KITTITAS COUNTY

DEPARTMENT OF PUBLIC WORKS

MEMORANDUM

TO: Community Development Services
FROM: Taylor Gustafson, Environmental/Transportation Planner *TG*
DATE: June 22, 2018
SUBJECT: County Review of Palomino Fields Plat Division 1 (LP-07-00031)

Surveyed by LMH Date 04-16 Scale 1" = 200'  
 Drawn by Tml/FCS Date 01-17 Sheet 1 of 6  
 Checked by BJB Date 07-17 Project No. 15169

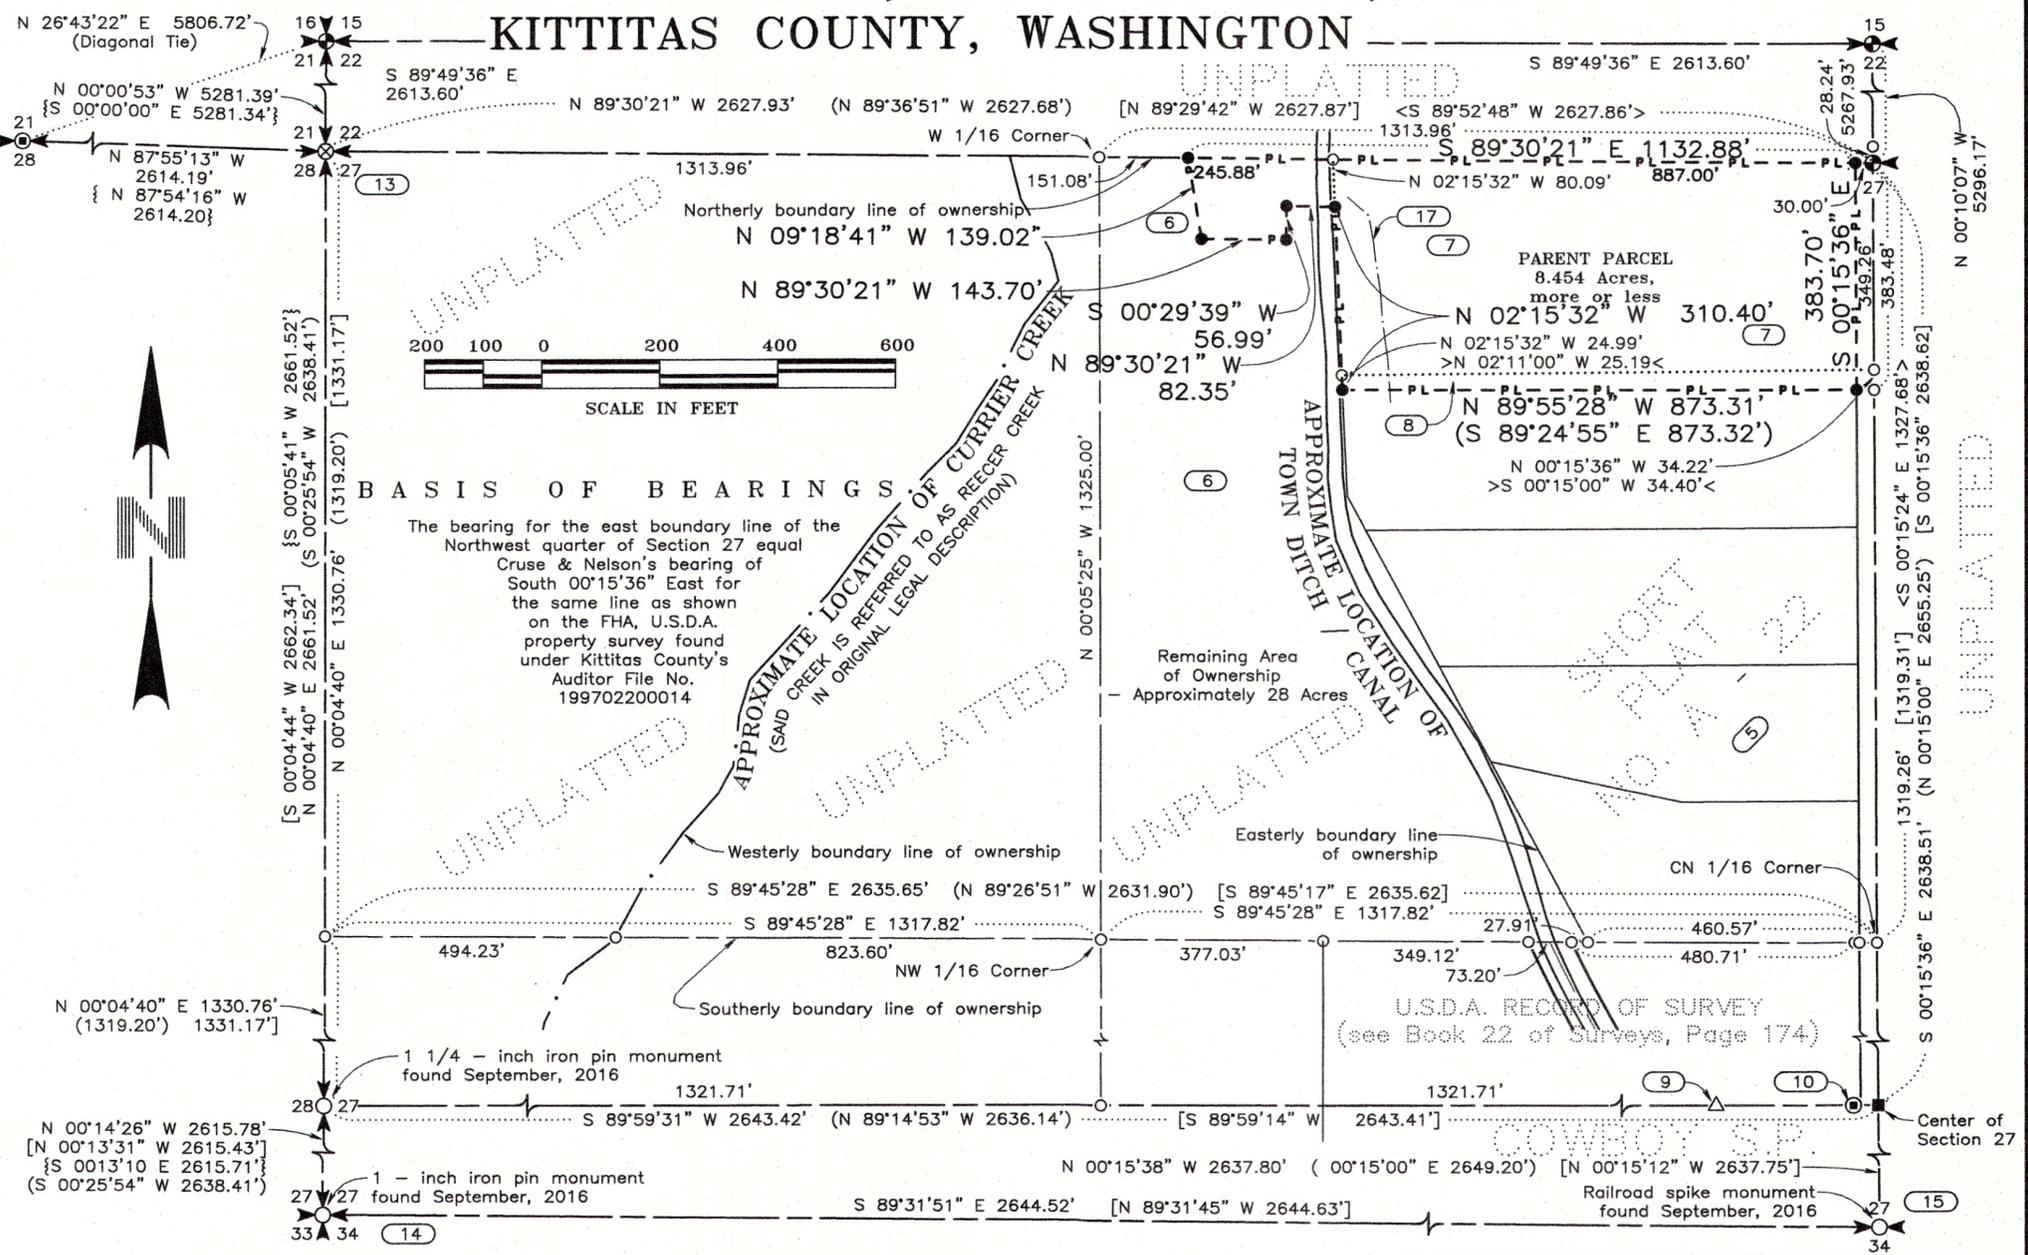
1. As noted previously, the surveyors statement shown has been taken from Kittitas County Code, rather than the statement per RCW:58.09.080. This creates a problem as all subsequent pages reference those persons named in the surveyor's certificate. The surveyor's certificate shown does not list anyone.
Alternatively, the Surveyor's Certificate could remain as is, and the 'Notice' on all subsequent pages could be removed.
2. The remainder of the parcel has not been identified as a lot, block, parcel or tract.

File --- Project Desc: S:\15169\15169 MP1.pro (Plotted - Feb 20, 2018) --- PROJ. NO. 15169 - AMENDED PALOMINO - DIV I

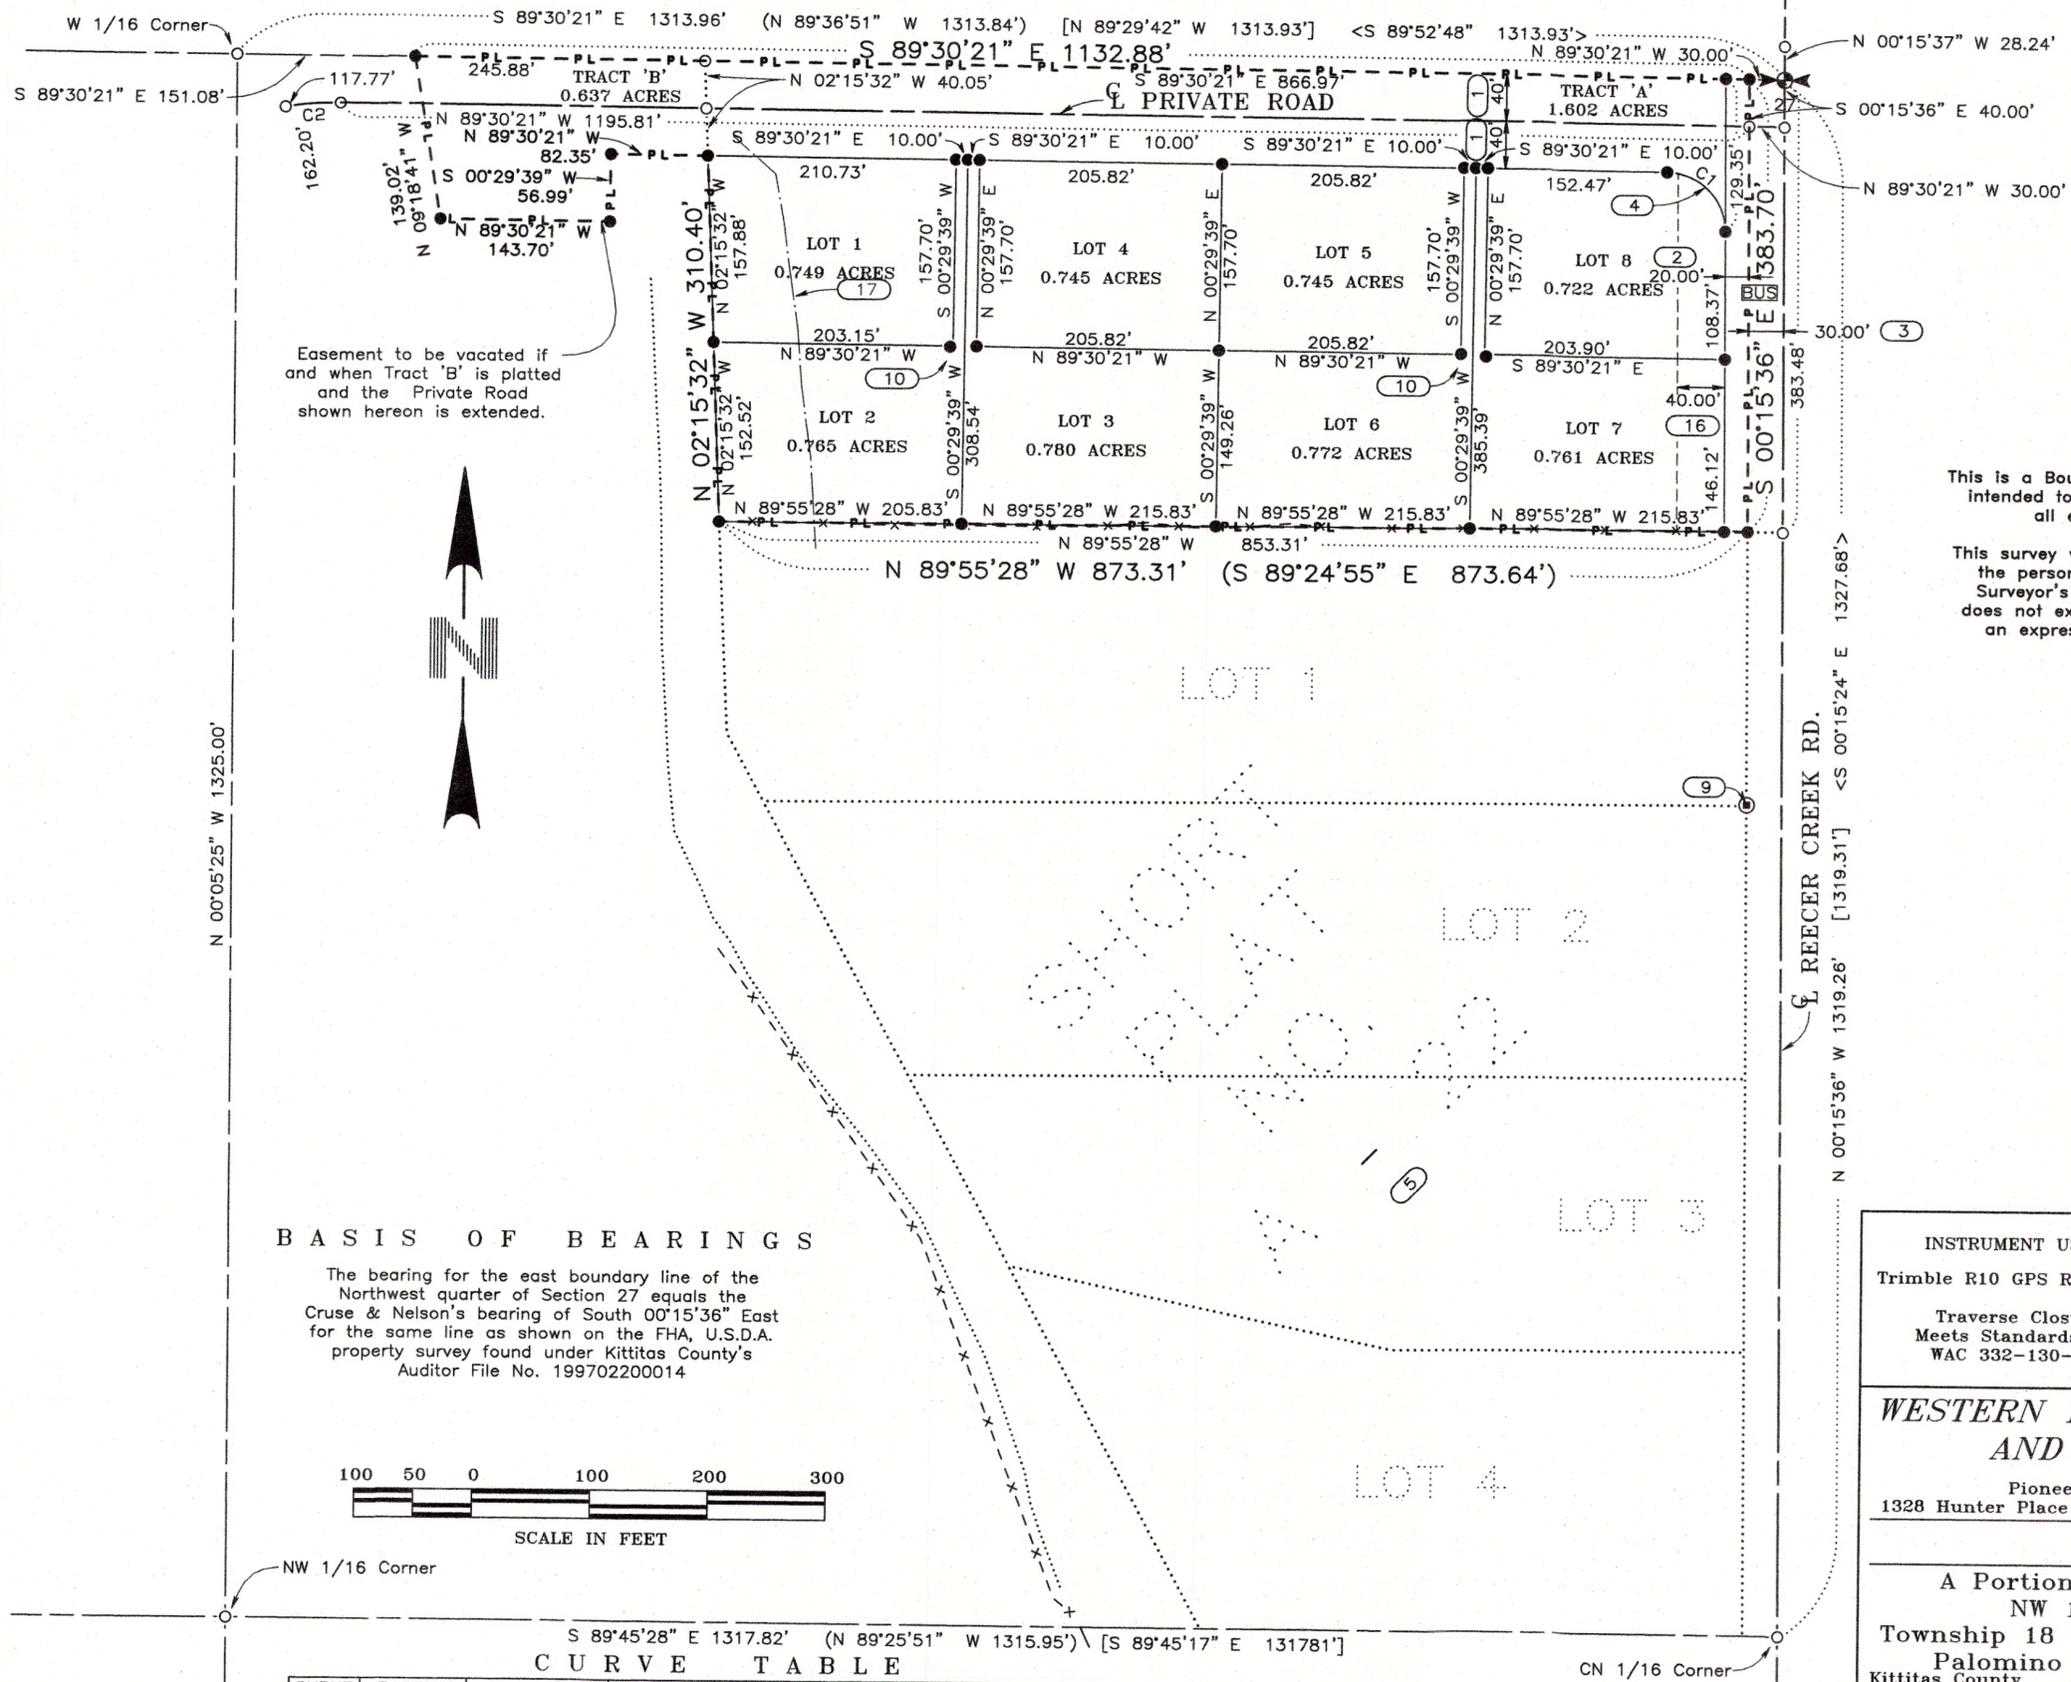
3. Corner symbols are obscuring the text at North edge of the subject parcel (S89°30'21"E).
4. There is text crossing text north of Lot 8.
5. The West line of Lot 1 shows different bearing on either side of the parcel line. The distances also show a small discrepancy ($1577.88 + 40.05 \neq 234.89$).
6. The North boundary dimensions of lots 3 and 7 are obscured by a symbol.
7. The symbol noted in #6 above is not included in the legend.
